CONSULTEE RESPONSE (Council's Arboriculturist)

Reference: WA/96/25/T

Location: 16 Walberton Park, The Street, Walberton, BN18 0PJ

Proposal: Crown reduction to 18no. lime trees to leave: (T1) height of 16.5m, spread of 6.5m (N), 7m (E), 2m (S), 3m (W), (T2) height of 16.5m, spread of 5m (N), 7m (E), 4m (S), 3m (W), (T3) height of 16.5m, spread of 5m (N), 6m (E), 4m (S), 3m (W), (T4) height of 16.5m, spread of 5m (N,S), 7m (E), 4m (W), (T5) height of 16.5m, spread of 5m (N, W), 6m (E, S), (T6) height of 16.5m, spread of 5m (N, W), 6m (E, S), (T8) height of 16.5m, spread of 5m (N), 4m (E), 3m (S, W), (T9) height of 16.5m, spread of 6m (N,E,S,W). (T10) height of 16.5m, spread of 4m (N), 6m (E,S), 7.5m (W). (T11, T12) height of 16.5m, spread of 5m (N, E, S), 7m (W). (T13) height of 16.5m, spread of 6m (N), 4m (E), 5m (S), 7m (W). (T14) height of 16.5m, spread of 5m (N), 4m (E, S), 8.5m (W). (T15) height of 16.5m, spread of 5m (N, S), 4m (E), 7.5m (W). (T16) height of 16.5m, spread of 5m (N, S), 4m (E), 7m (W). (T17) height of 16.5m, spread of 6m (N, S), 4m (E), 7.5m (W). (T18) height of 16.5m, spread of 8m (N, W), 5m (E), 6m (S). (T19) height of 16.5m, spread of 6.5m (N), 5m (E), 6m

Figure 2 Positions of final cuts

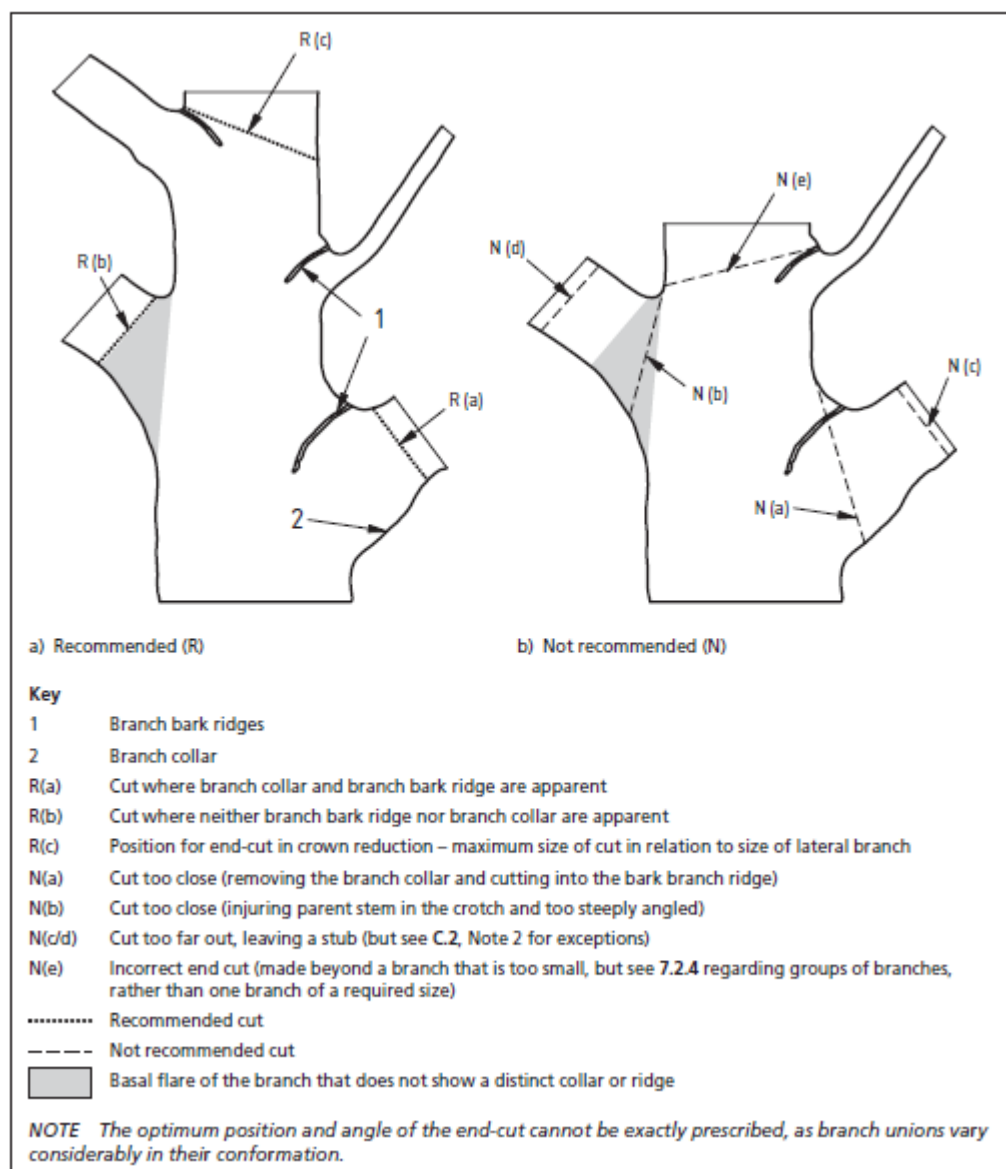
Part a) Where whole branches are to be removed and final cuts made close to the trunk or branch union they are to be made as shown in Figure 2 of BS3998:2010
